Rezoning Transportation Analysis

Petition Number: 2020-052

General Location Identifier: Tax ID 15101603

Date	Description
4/20/20	First Review
08/25/20	Second Review (Lynda Jensen)

JOB # 20005
DATE 03/06/20
SCALE: 1" = 20'
DRAWN BY: JAW
APPROVED BY: JCO
RZ 1.0

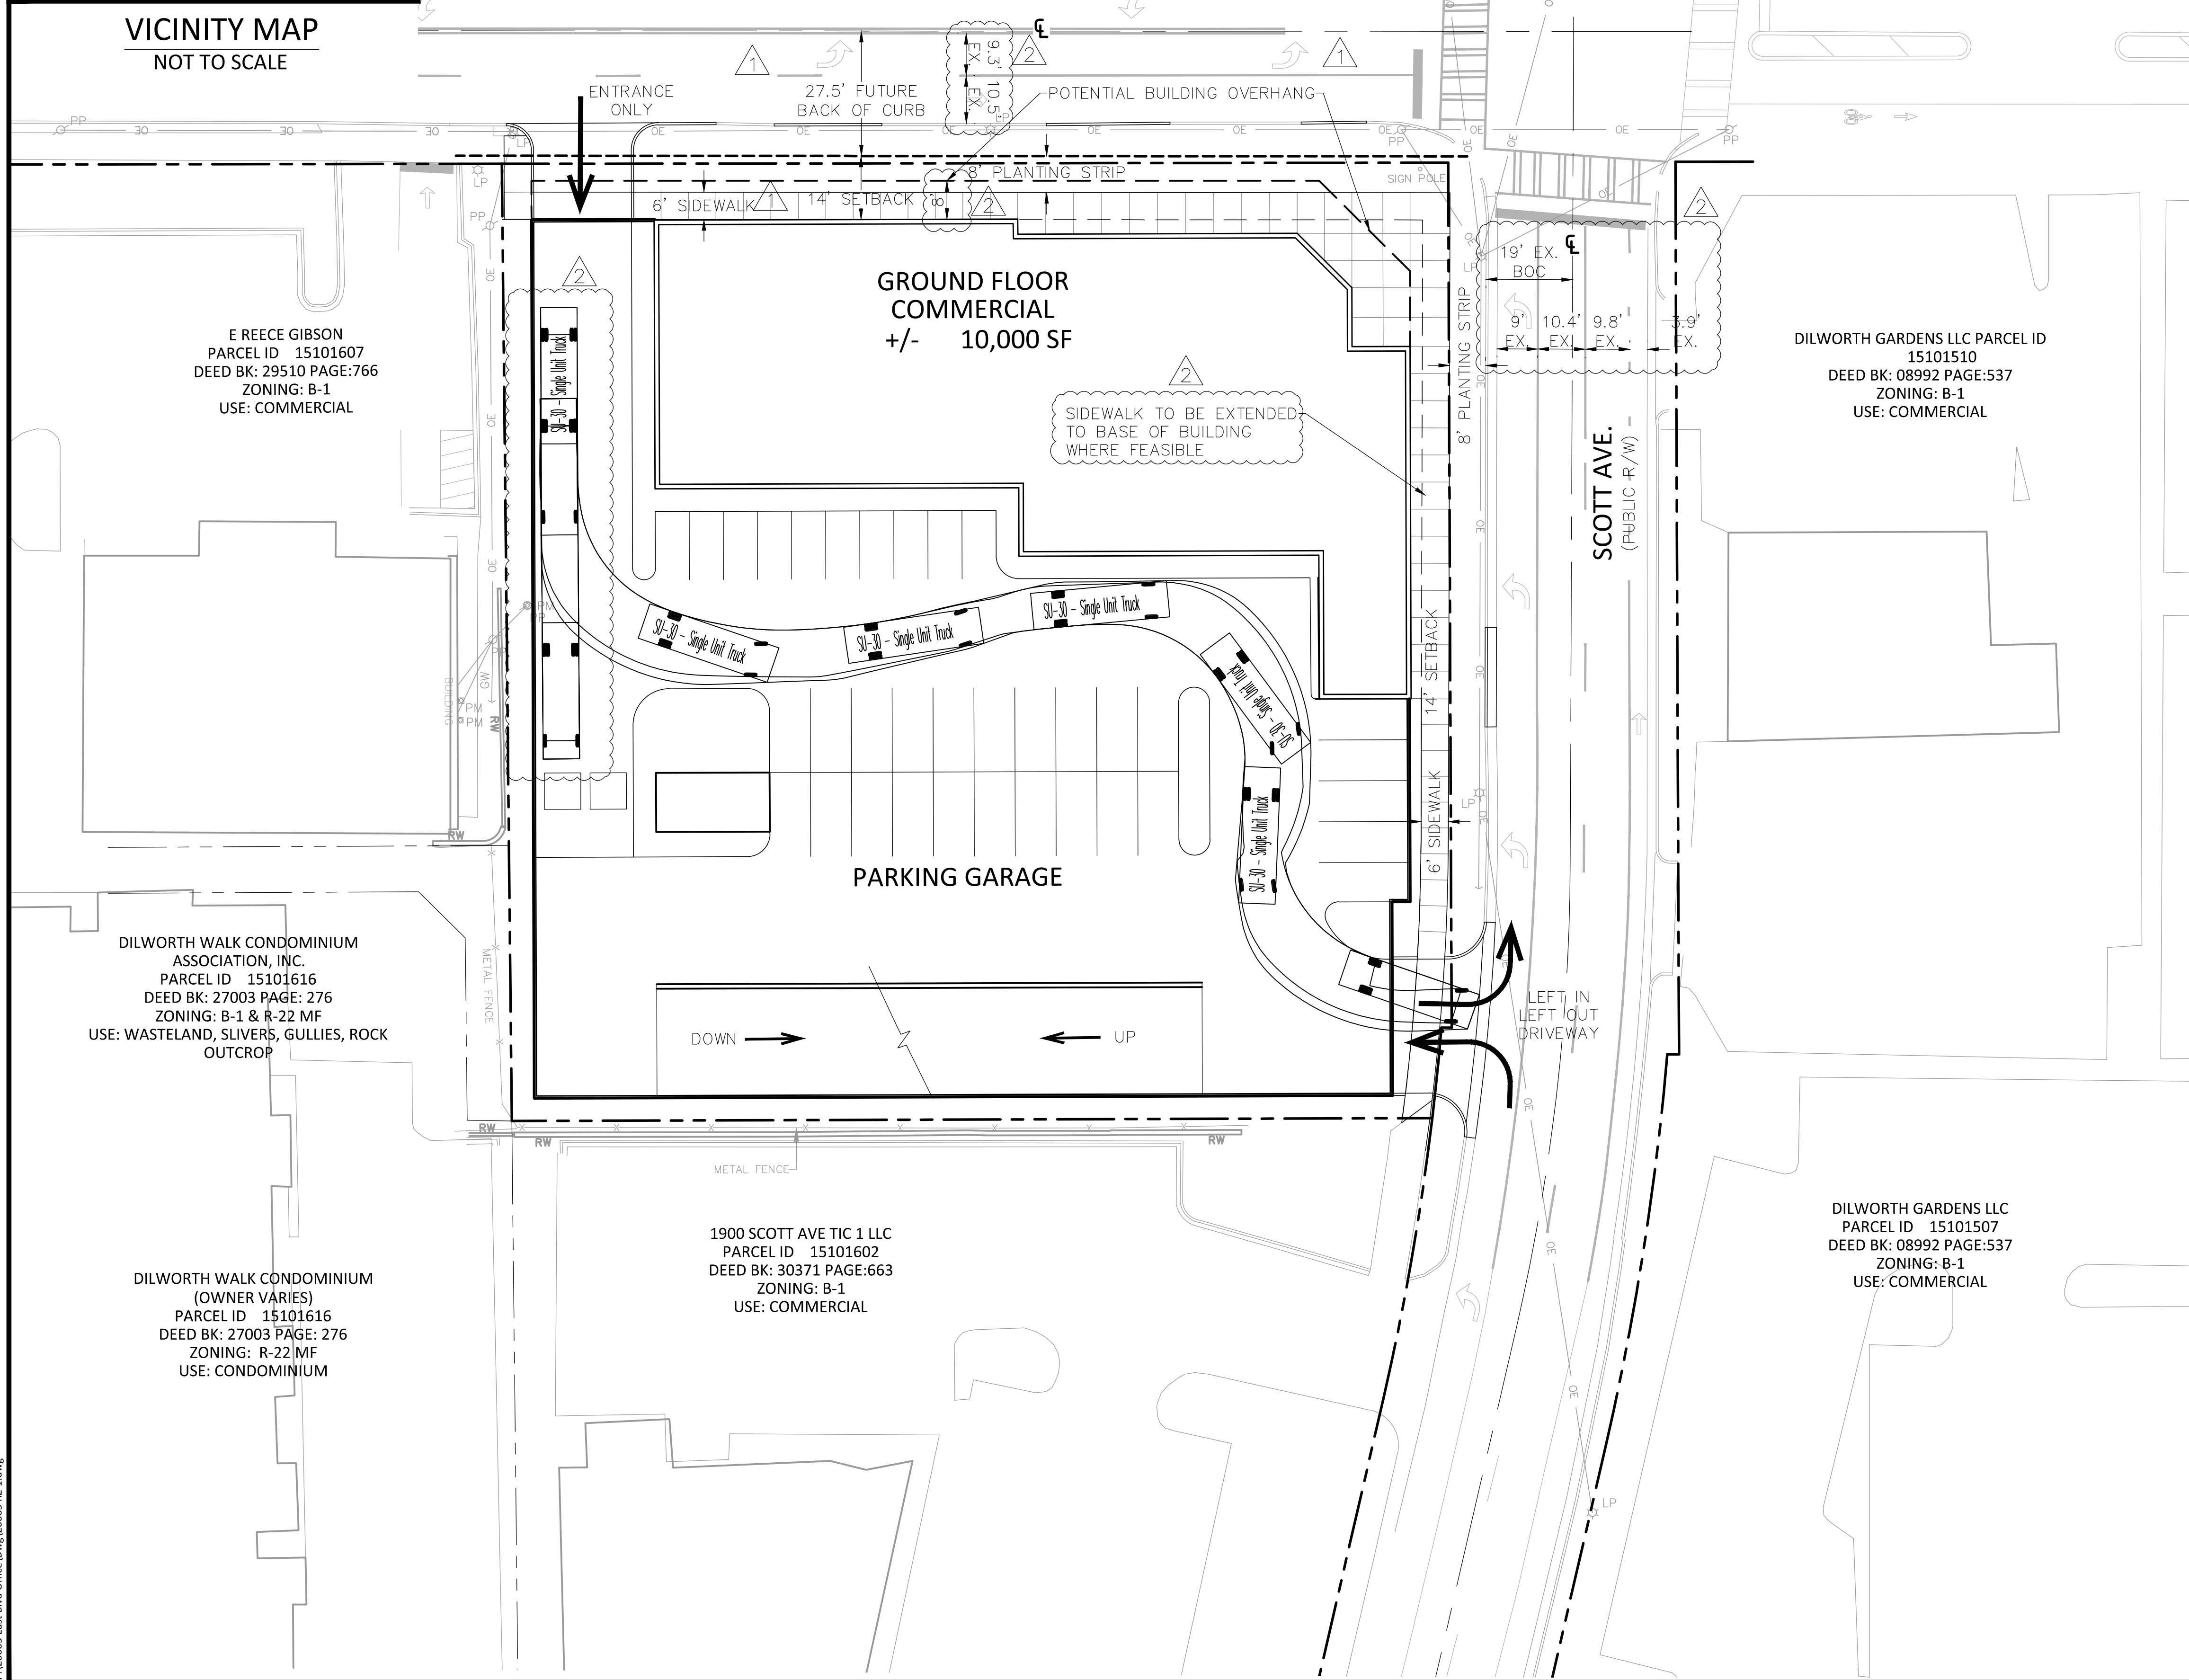
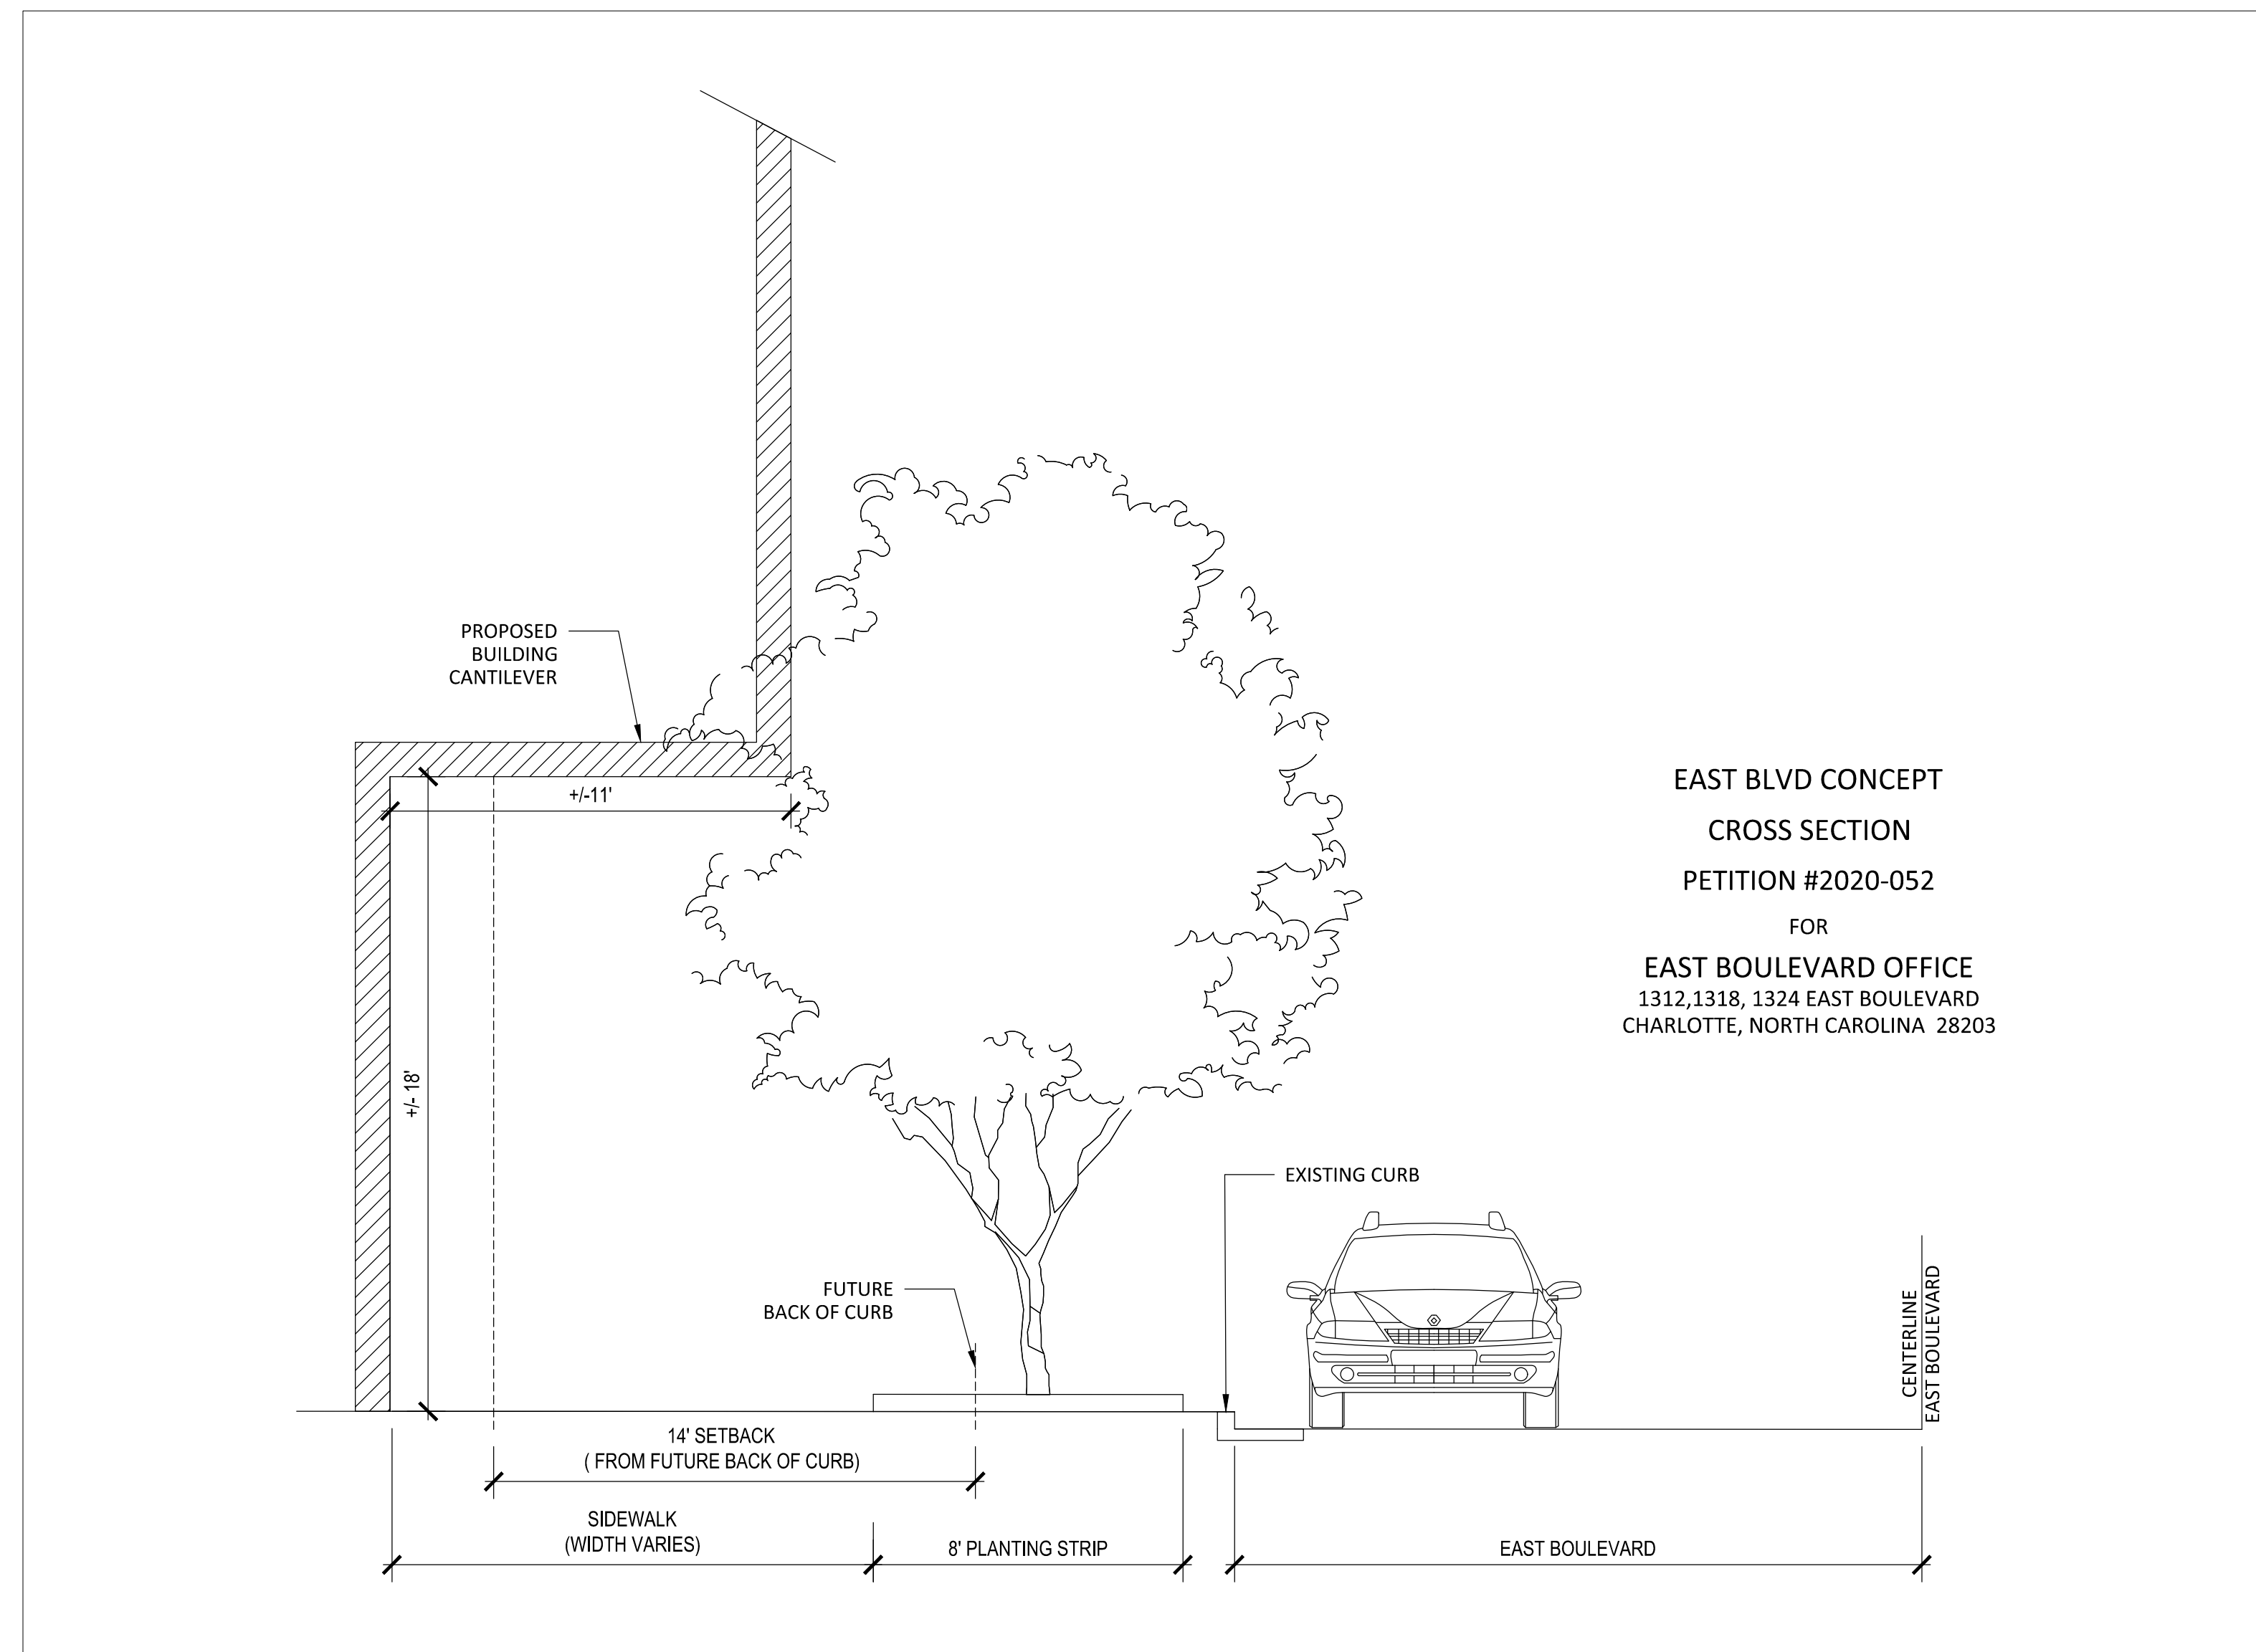
1. **Curbline:** The proposed zoning district has a setback measured from back of the existing or proposed future curbline.
 - a. **Scott Ave.:** The future location of curb and gutter is in its existing location.
 - ~~b. **East Blvd.:** The proposed curbline and setback need to be revised from what is shown on the site plan. The East Blvd. Pedscape Plan (2002) prescribes a 54-foot back-of-curb (BOC) to back-of-curb dimension with a 12-foot setback. However, this plan predates the East Blvd. Road Diet (circa 2005), the Urban Street Design Guidelines, Charlotte WALKS, and Charlotte BIKES. After considering all of these plans, the future curbline should be 55-foot BOC-BOC (27.5-foot centerline to BOC) with a 14-foot setback:~~
 - ~~• Four 10-foot vehicle lanes~~
 - Two 5-foot standard bike lanes
 - Two 2.5-foot curbs and gutters
 - ~~• Two 14-foot hardscape setbacks~~

The petitioner should revise the site plan should show the curb and gutter labeled and dimensioned from the centerline for each road. The petitioner may move the curbline as described or provide additional hardscape (with trees in tree pits corresponding to their future location).

3. ~~The proposed driveway to East Blvd. needs to be a one-way-in-only driveway,~~ matching what has been built at the site across East Blvd. The parking deck needs to accommodate the on-site servicing of dumpsters and circulation of SU-30 vehicles to Scott Ave.

4. The petitioner should revise the site plan to add a note specifying dedication and fee simple conveyance of all rights of way to the City before the site's first building certificate of occupancy is issued. CDOT requests right of way set at 2' behind back of sidewalk, or to face of building, as appropriate.
